Address: 33 Whitley Road Dewsbury WF12 0LP

Application number: 2021/91709	
What is the application for?:	Alterations to private driveway to create additional parking space via suspended
Address of the site or building:	35, Whitley Road, Thornhill, Dewsbury, WF12 0LP
Postcode:	WF10 3HP

TITLE:
PROPOSED CAR PORT
EXISTING & PROPOSED PLANS

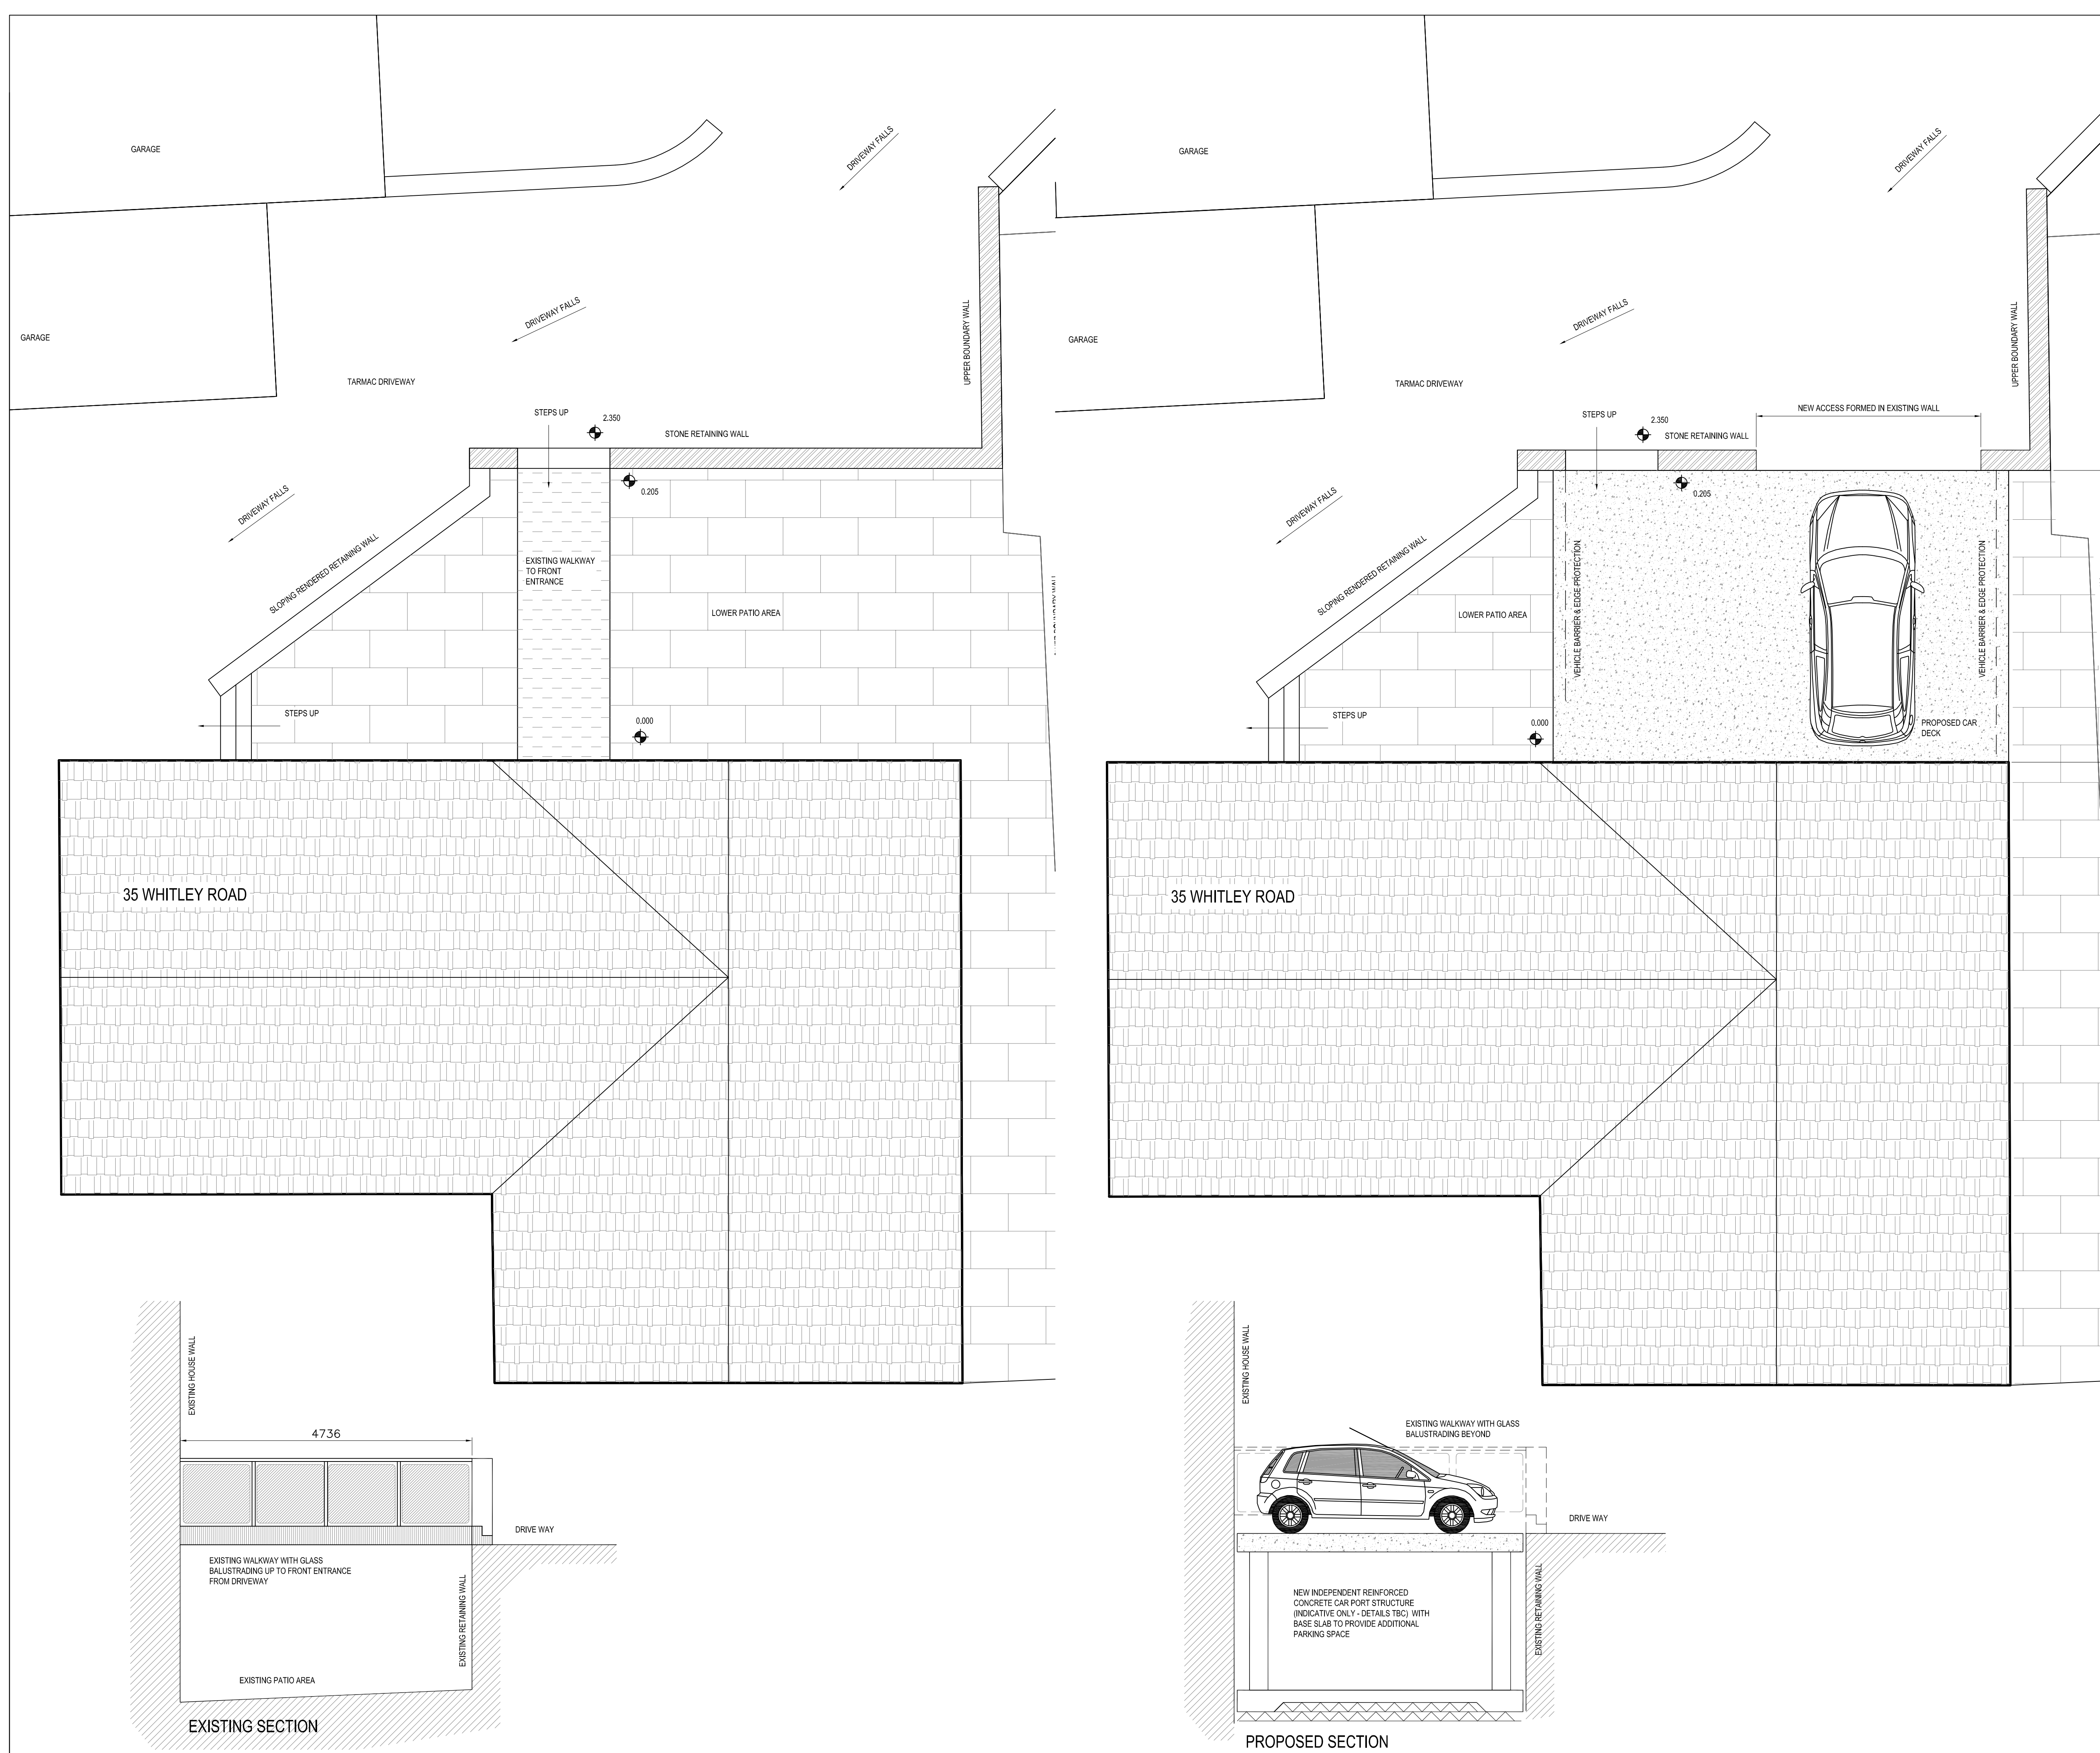
Type of comment: A general comment	
Do you wish your comments to be published on the website anonymously?	No
We are the neighbouring detached property at 33 Whitley Road. We would very much like to make a comment (not an objection) regarding the safety standards from our perspective. This is specifically, due to the proposed suspended driveway been above us and how it might impact on us. We would like to be reassured that the proposed suspended driveway will comply with all regularity and safety standards and that planners will view the plans from our orientation beneath. In addition, we would like to understand how the structure will look aesthetically and more about the size and structure from our perspective.
